A47 Blofield to North Burlingham

Scheme Number: TR010040

Volume 8 **8.13 Statement of Common Ground** **with National Highways** **and Blofield Parish Council**

STATEMENT OF COMMON GROUND

|  | SUITABILITY |

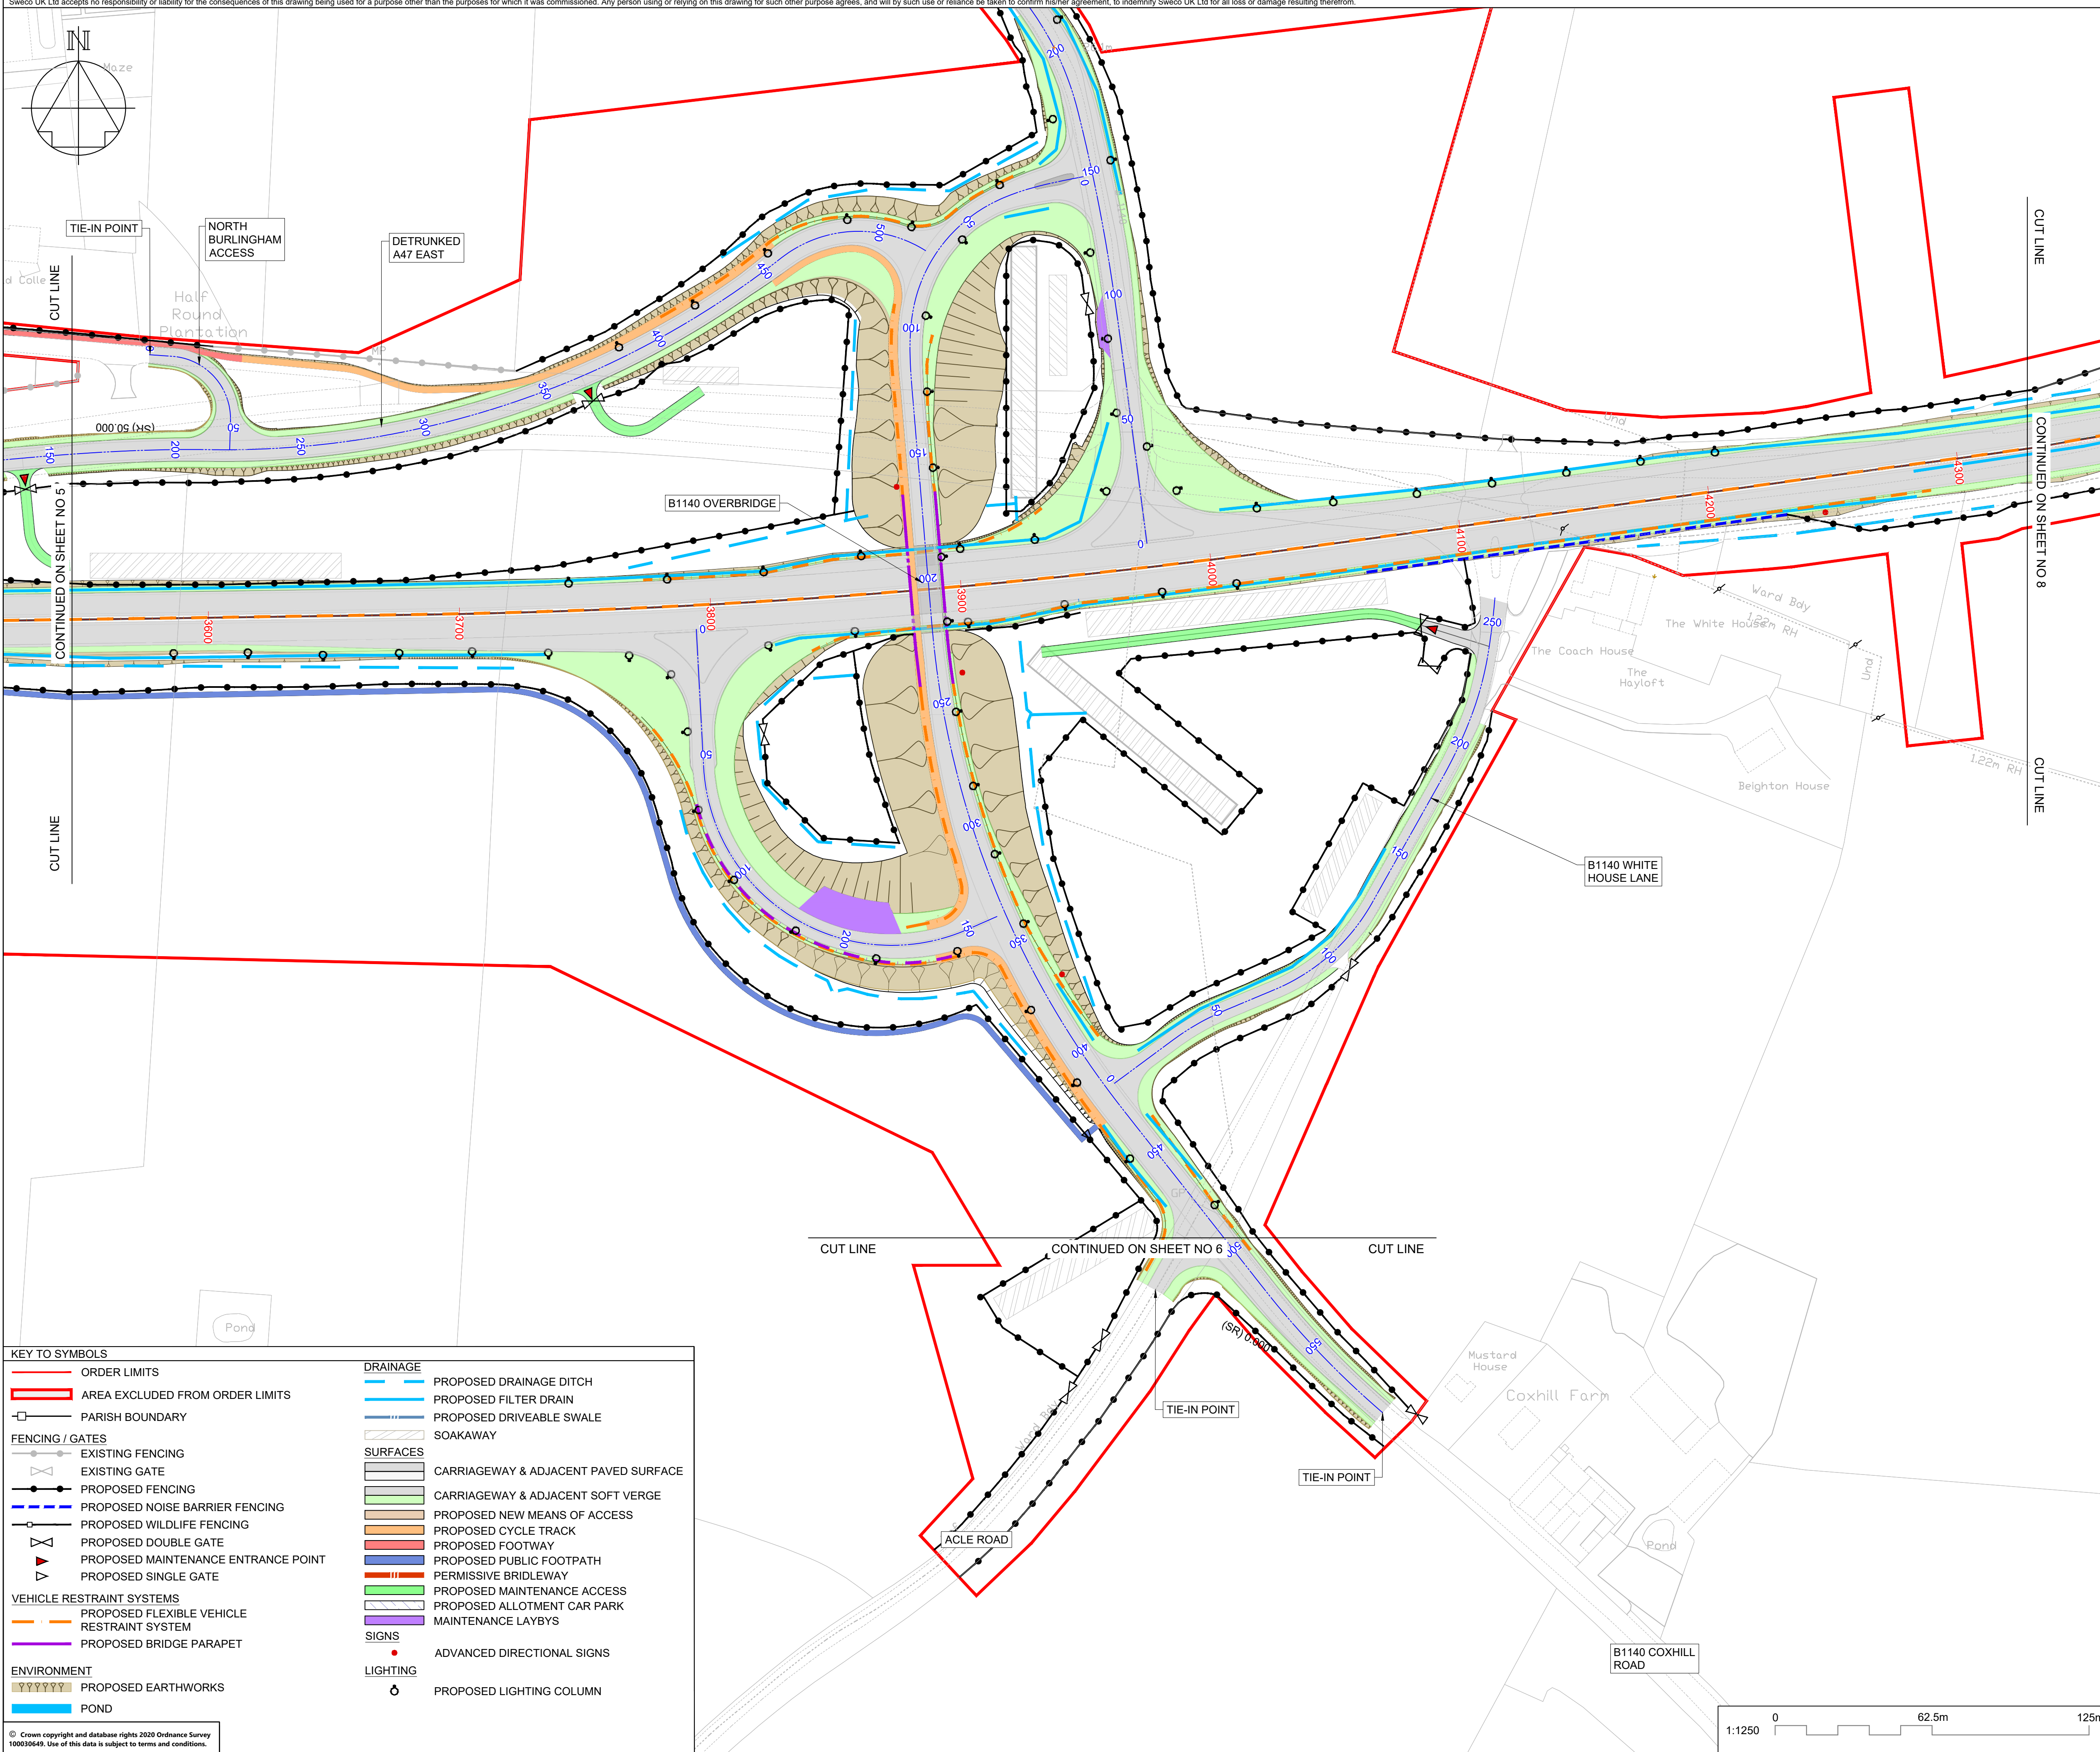
Issue	Document Reference	Blofield Parish Council Comment	Applicant's Response	Status	Date
Blofield Allotments – Water tank	Email from BPC in Appendix F	Unless a new water tank is being provided by HE, the existing one will need to be moved and operational within 48 hours if the move takes place between 1 April and 30 September, when the water supply is turned on and therefore in regular use. Outside these dates there is more flexibility.	See response above in relation to the water tank	Agreed	11-Nov-21
Blofield Allotments – Fencing	Letter from BPC in Appendix A & Letter from BPC in Appendix H	New rabbit proof fencing installed etc. and although these seem minor issues the plot holders are concerned.	The fencing design has been amended to reflect the concerns of the plot holders, as shown on the General Arrangement Plans (REP7-005).	Agreed	11-Nov-21
Blofield Allotments – Fencing	Letter from BPC in Appendix C	Will there be sufficient space to facilitate access to the two haulage ways on the main allotment plots?	The layout of the carpark and fencing has been amended to ensure access to the haulage ways on the main allotment plots, as shown on the General Arrangement Plans (REP7-005).	Agreed	11-Nov-21

Road Lighting	Letter from BPC in Appendix C, Appendix H & Appendix I	<p>2.6 General Arrangement Plans</p> <p>The proposed 20 lighting columns would be in contradiction of the Blofield Neighbourhood Plan Environment 5 Policy regarding Dark Skies. If the proposed junction was amended as per our suggestion at the beginning of this document, then the junction lighting would not be in contradiction to our local plan policy.</p>	<p>As described in the Scheme Design Report (REP1-046) lighting is proposed at the Yarmouth Road as road safety mitigation. The lighting will be LED and include back shields, where appropriate, to limit light spill.</p> <p>The modified junction arrangement as proposed by Blofield Parish Council is not a technically viable solution. Whilst Option B, considered in the Scheme Design Report (REP1-046) may not require lighting, it would have other environmental impacts resulting from the increased land take and additional construction.</p>	Agreed	20-Dec-21
